Written Representation of Bishopton Villages Action Group (BVAG)

Application by RWE Renewables UK Solar and Storage Limited
Proposed Development Consent for the Byers Gill Solar Project.

PINS ref: EN010139

29th August 2024

Site Area and assets in Detailed Setting Assessment: Asset Group 3 (Bishopton) and motte and bailey castled Scheduled Monument (NHLE1008668)

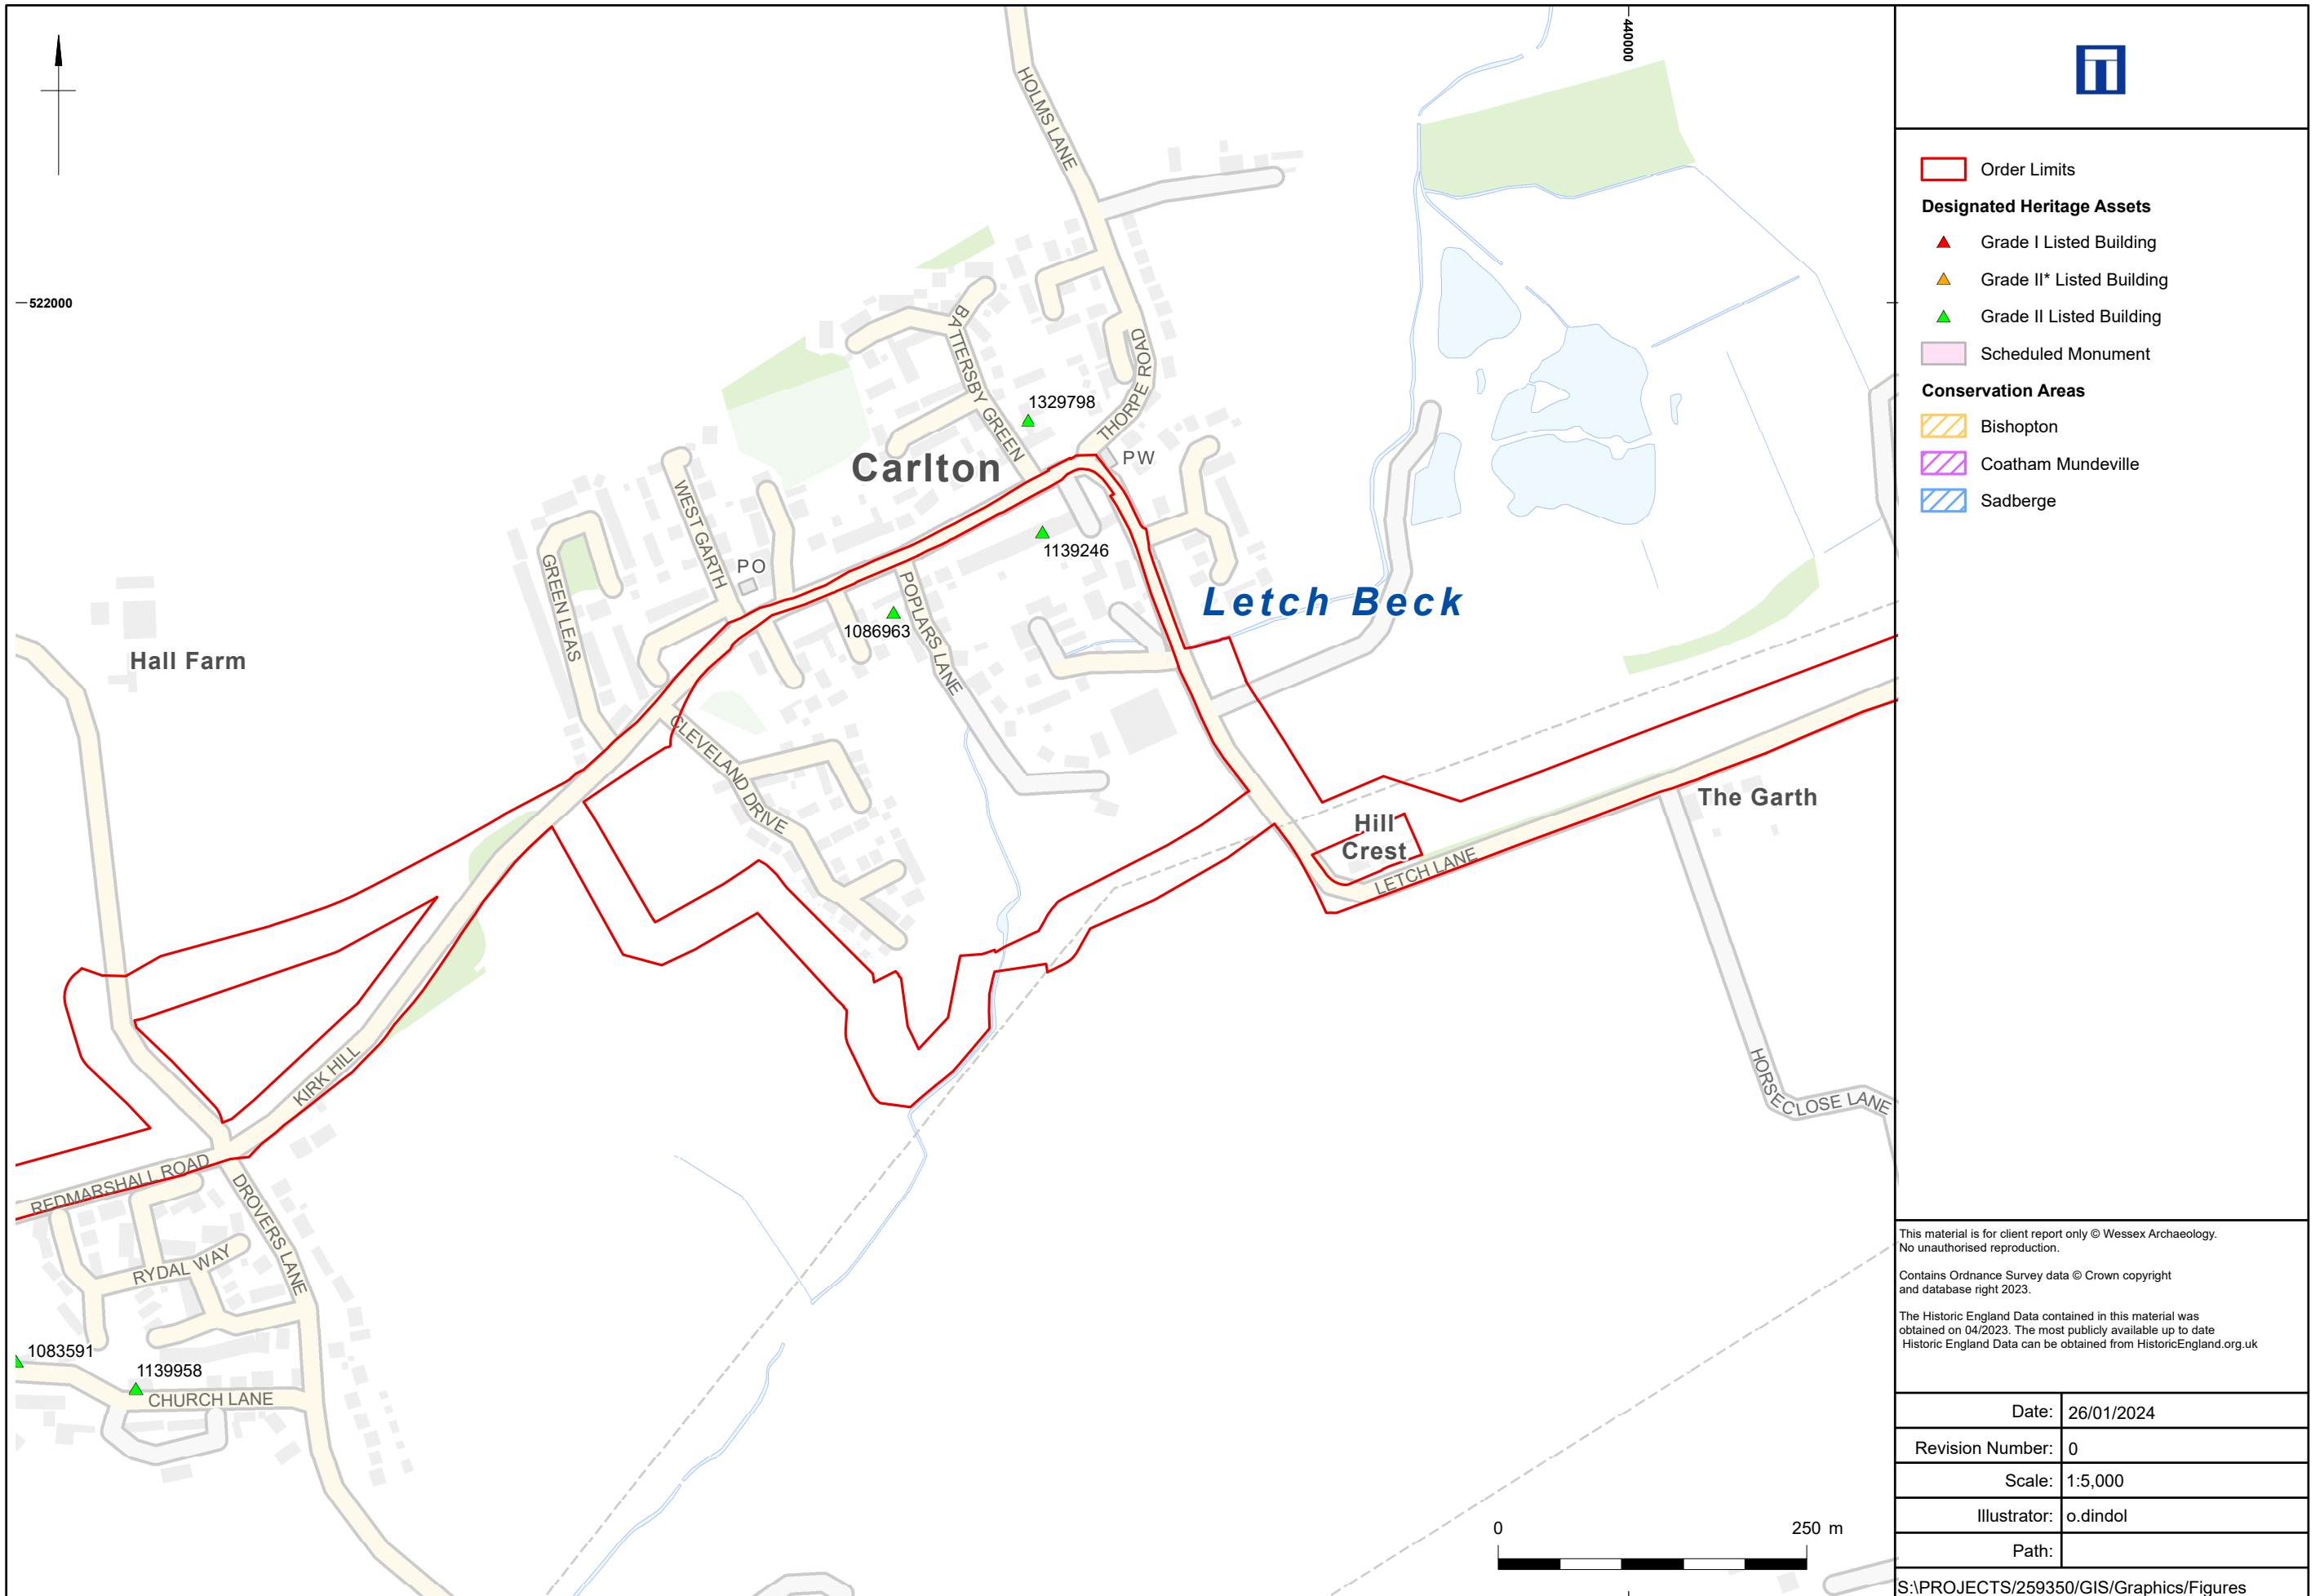
There is potential significant harm to local heritage and archaeological assets. The project could significantly impact the Bishopton Conservation Area, including views and settings of historic assets like the 12th-century Bishopton Motte and Bailey as well as archaeology around this Scheduled Monument. BVAG disagrees with RWE's conclusion that there will be no significant cultural heritage effects and calls for further assessments. Concerns are raised about potential archaeological damage due to the exclusion of critical areas from geophysical surveys and trial trenching.
